DEVELOPMENT REVIEW BOARD - HYDROLOGY SECTION
 Renée Brissette, PE, Senior Engineer | 505-924-3995 rbrissette@cabq.gov

DRB Project Number: 2019-003062 Hearing Date: 01-08-2020
 Project: Lots A-3-A-1 & A-3-A-2, Thunderbird Partnership Agenda Item No: 18

**Sketch Plat**  
**Lots A-3-A-1 and A-3-A-2**  
**Thunderbird Partnership**  
 comprised of  
**Lot A-3-A**  
**Thunderbird Partnership**  
 City of Albuquerque  
 Bernalillo County, New Mexico  
 January 2020

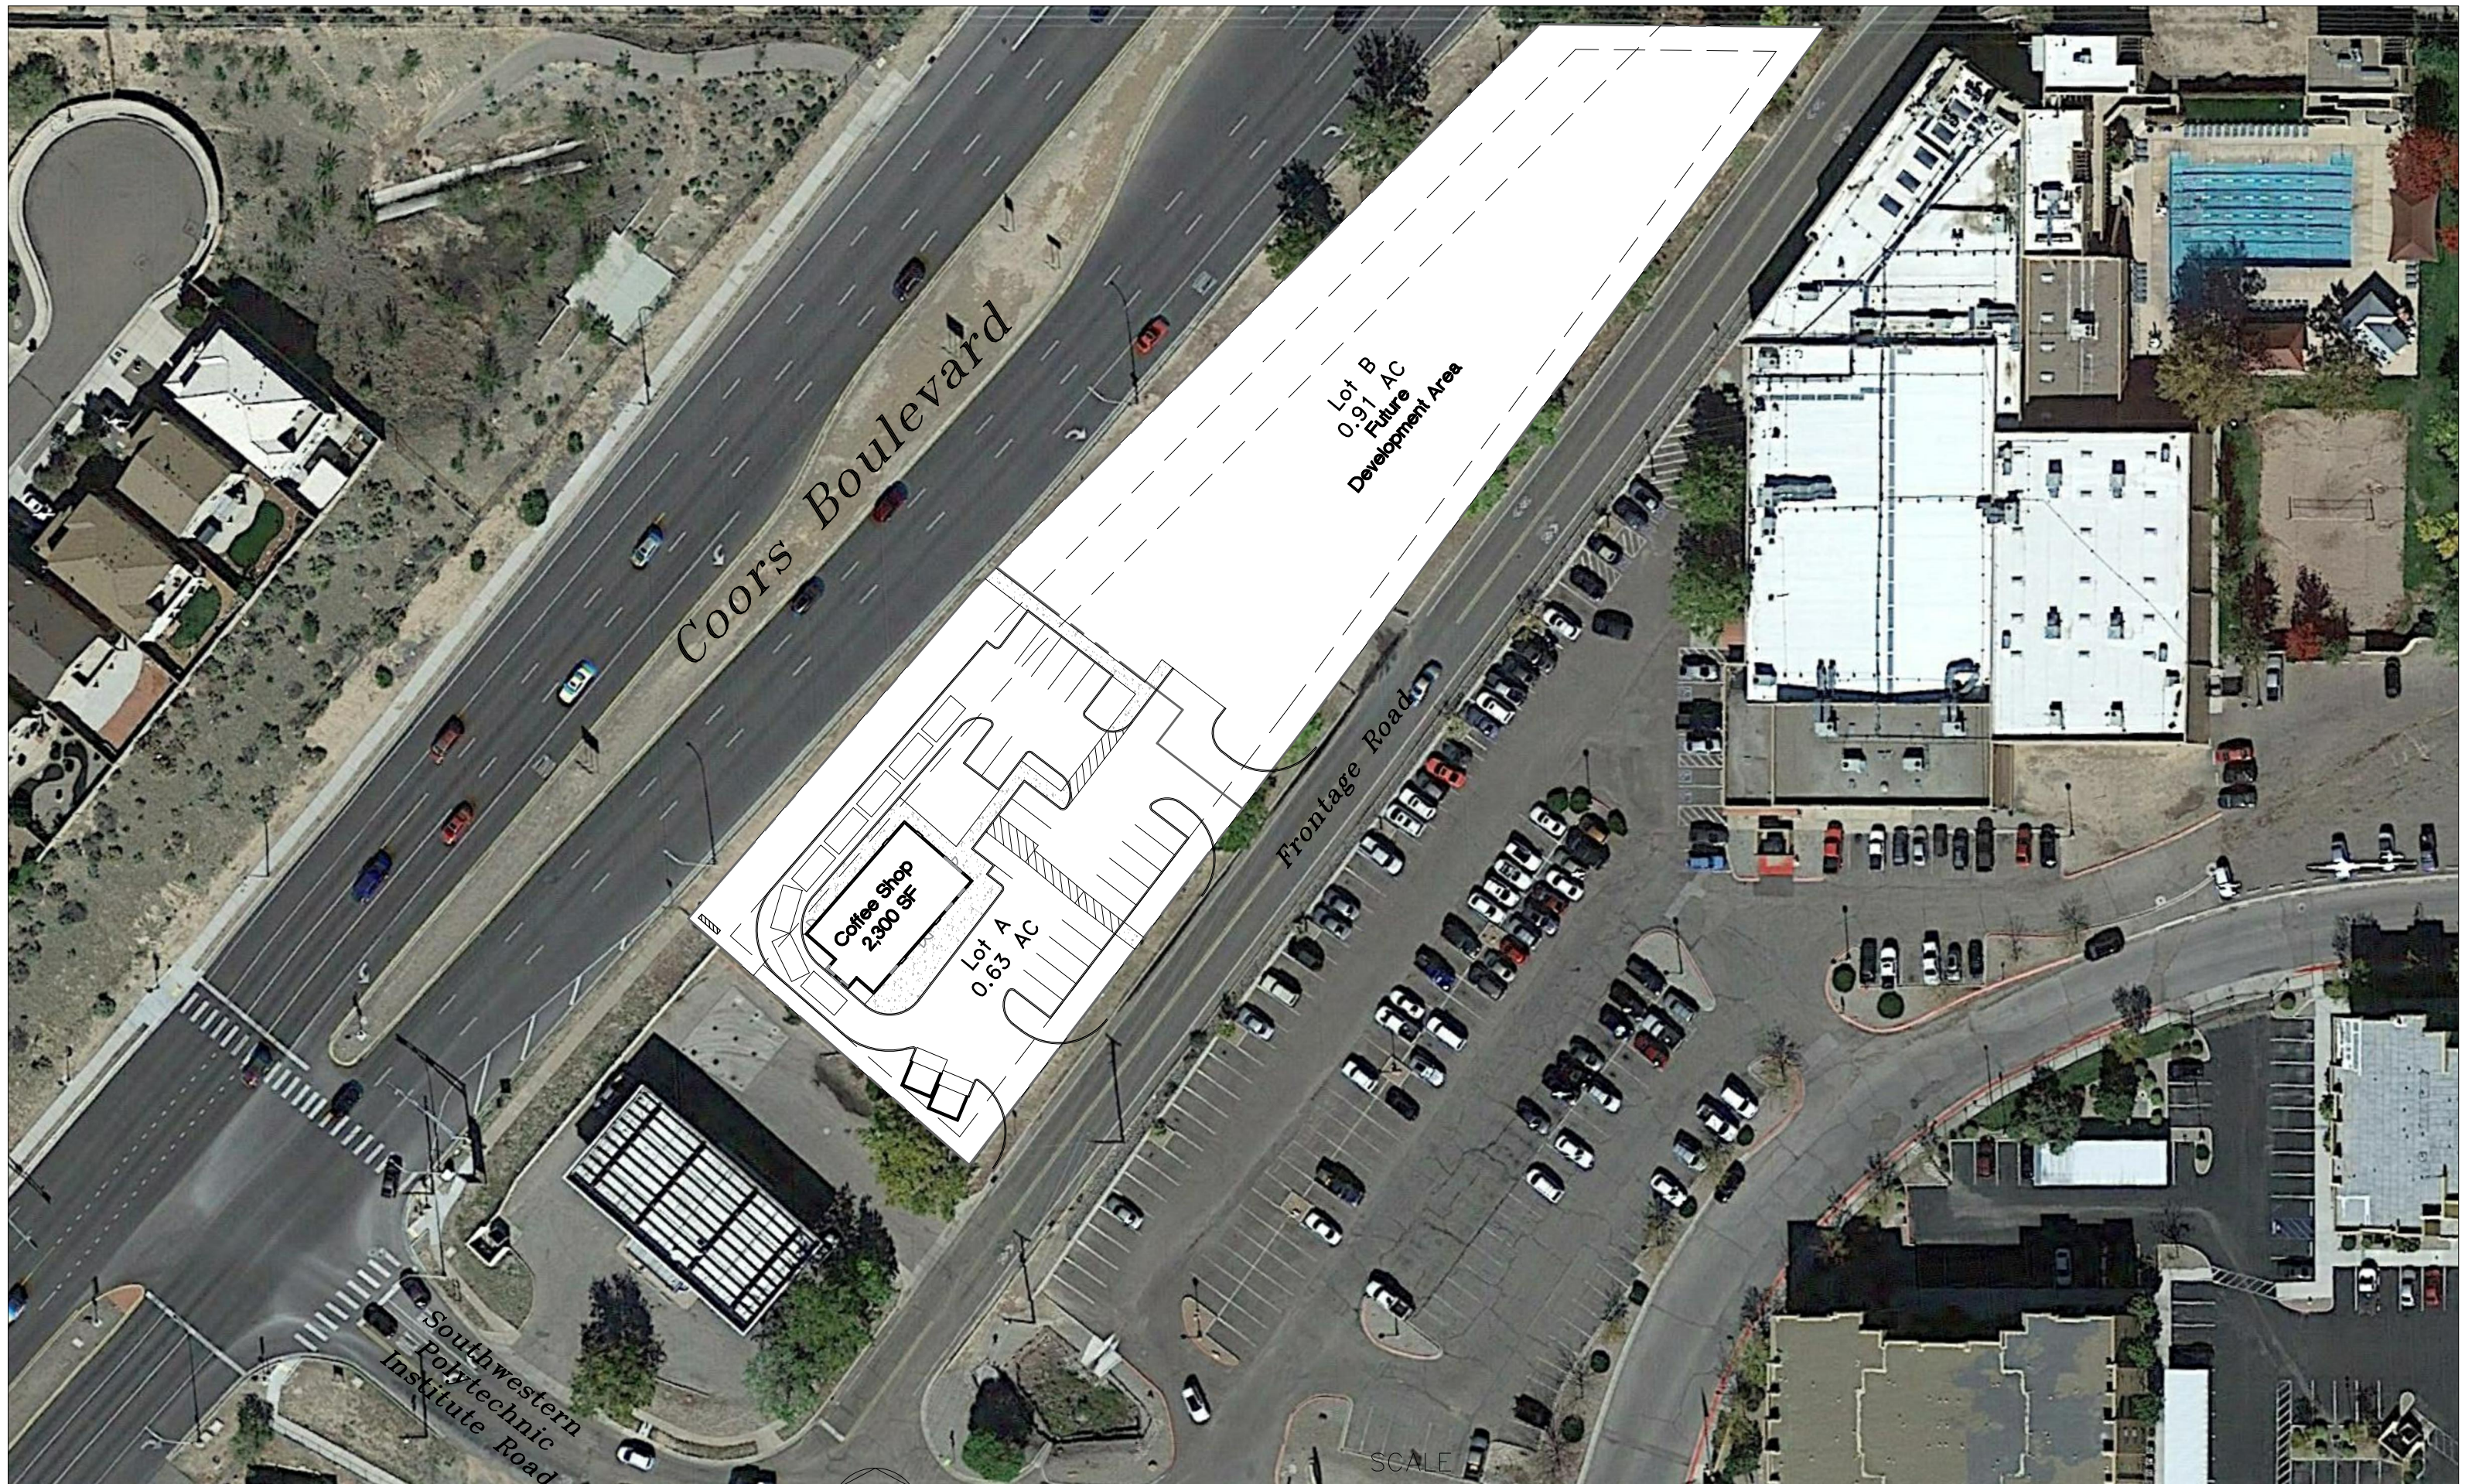
- Hydrology will need an approved Grading and Drainage Plan prior to approval of Preliminary Plat or Site Plan for Subdivision.
- A Cross Lot Drainage Easement note specifying the beneficiary and maintenance agreement may be needed depending on the approved G&D.
